Ribble Valley Borough Council

App. Ref: 3/2025/0873

Address: Land at Springwood Drive, Whalley

Proposal: Construction of 6 detached dwellings with associated parking and landscaping at land off Springwood Drive

DRAWING TITLE.
SITE LAYOUT PLAN

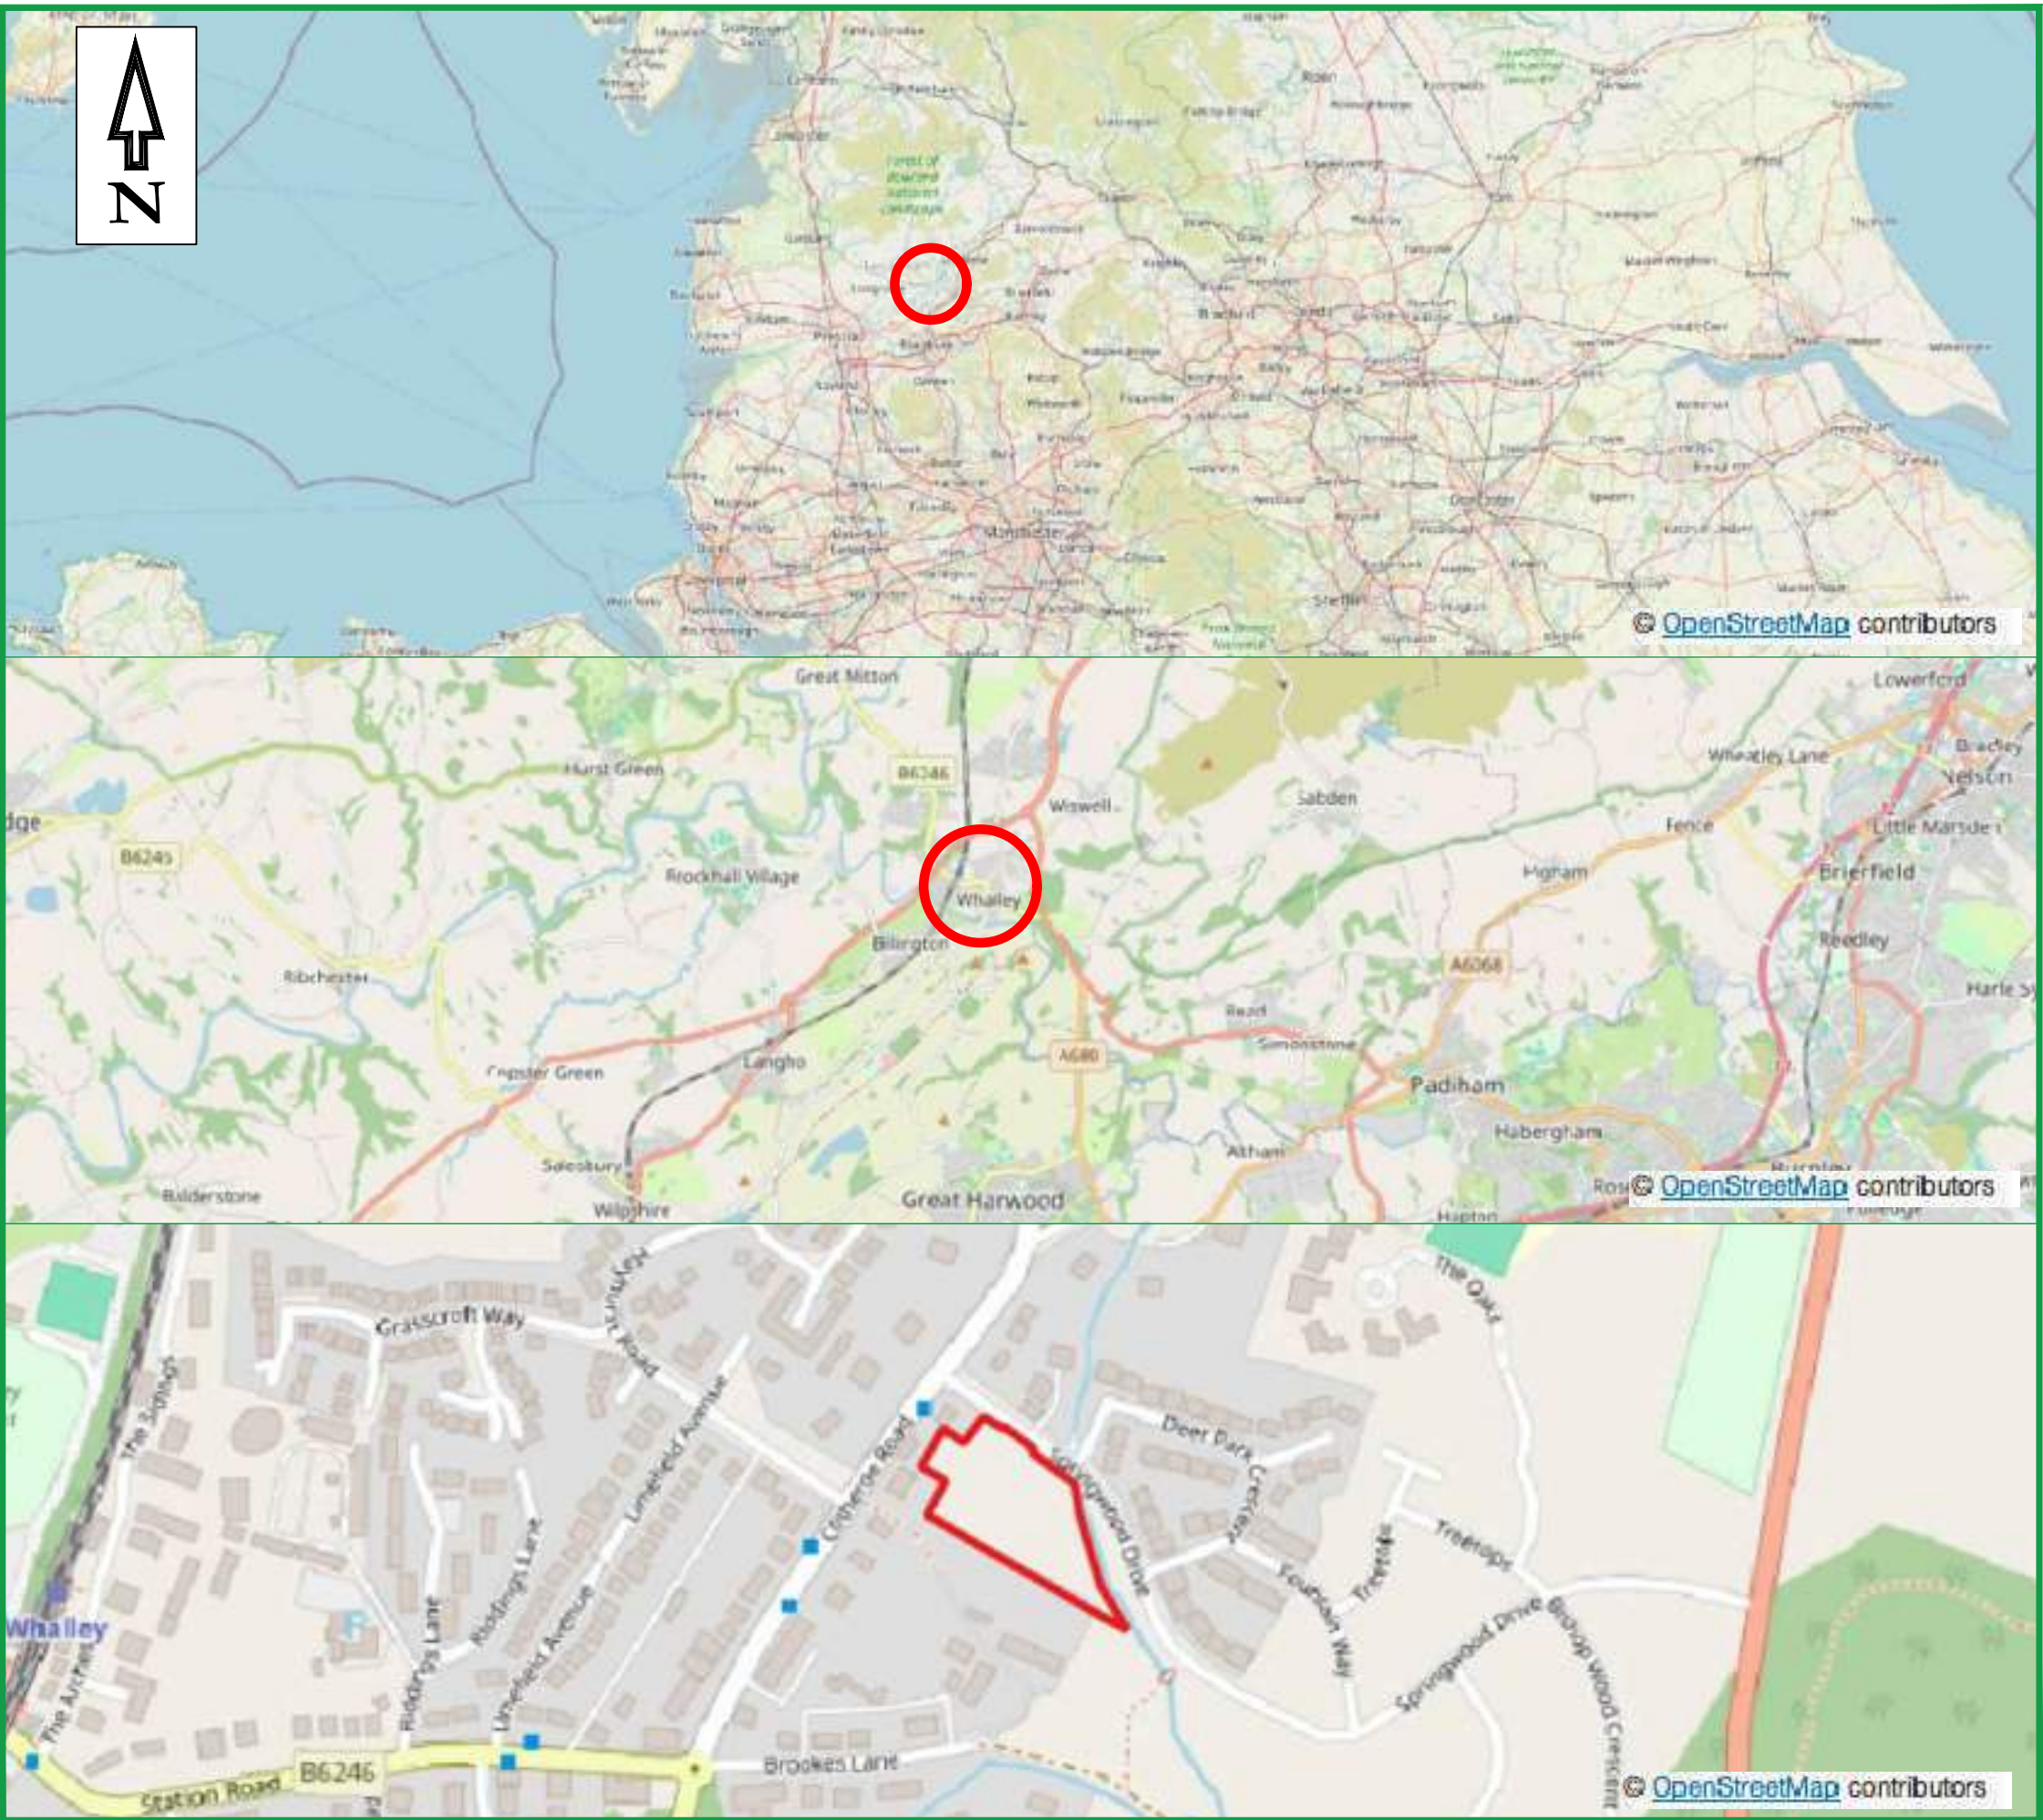
There is a new retaining wall proposed on the highway boundary of Springwood Drive, only to the south east side of the proposed site access, shown on the boundaries drawing as 'stone wall/retaining stone wall height varies depending on site levels'. We advised that we would not accept any highway retaining structures, please advise if this annotation is relevant for this section or if this is a boundary wall only. Detailed engineering drawings, cross section and calculations and a structural agreement will be required if this retains the highway. Parapet protection and vehicle restraint risk assessment will be required. A maximum embankment gradient of 1:3 is acceptable.

The carriageway is 5.5m wide initially with 2m wide footways. The footways should continue fully around the turning head to be to adoptable standards and as a minimum (if not being offered for adoption) at least with a footway in front of plot 2 and opposite plot 4 up to the shared drive.

There is a proposed surface water 'attenuation area' located beneath the estate road, which is proposed to be connected to the UU combined sewer. This should be relocated onto a private area to comply with LCC adoption standards (if the estate road is being offered for adoption).

The turning head should be tracked for a 10.2m long refuse vehicle.

2. Prior to commencement details of the retaining structure alongside the highway boundary of Springwood Drive shall be submitted for approval by the LPA. The approved details shall be implemented under an agreed timetable.
